PCD File: MS2211

Re: Letter of Intent . . . NABULSI-ABUSHABAN SUBDIVISION

FINAL PLAT  
NABULSI-ABUSHABAN  
SUBDIVISION

NABULSI-ABUSHABAN SUBDIVISION

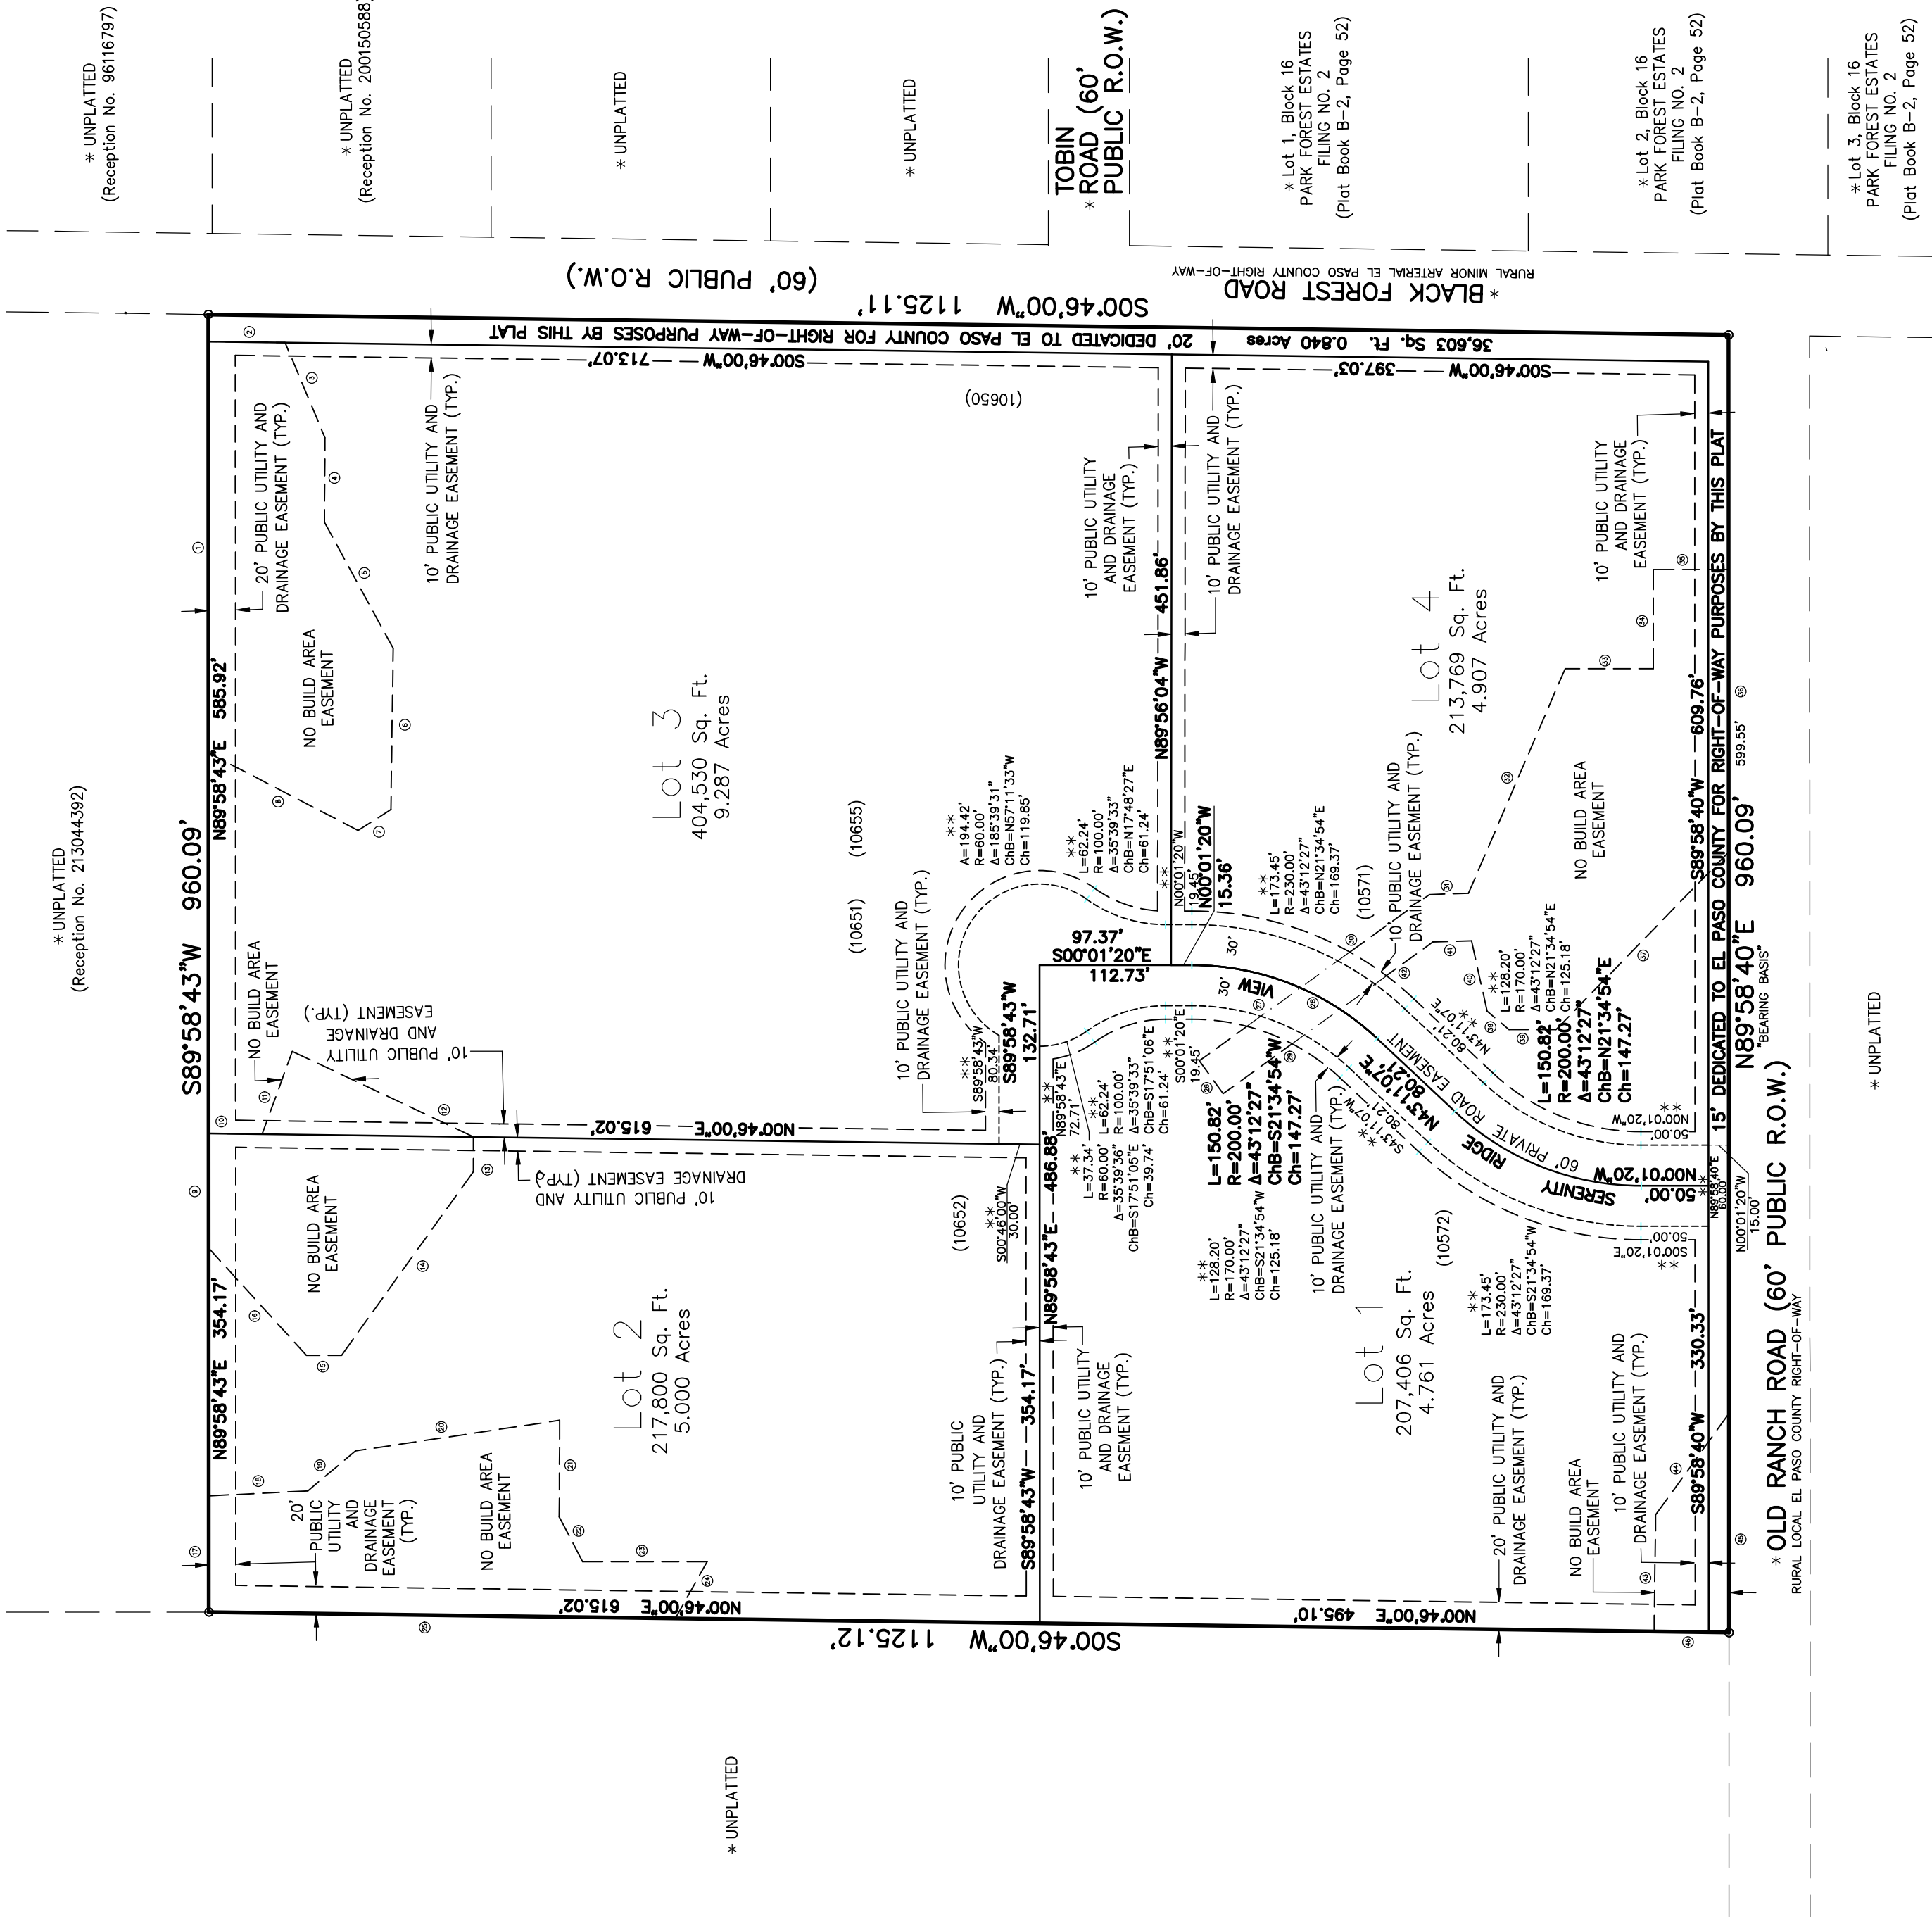
Please add a discussion  
regarding the no-build  
areas / constraints on  
each lot.
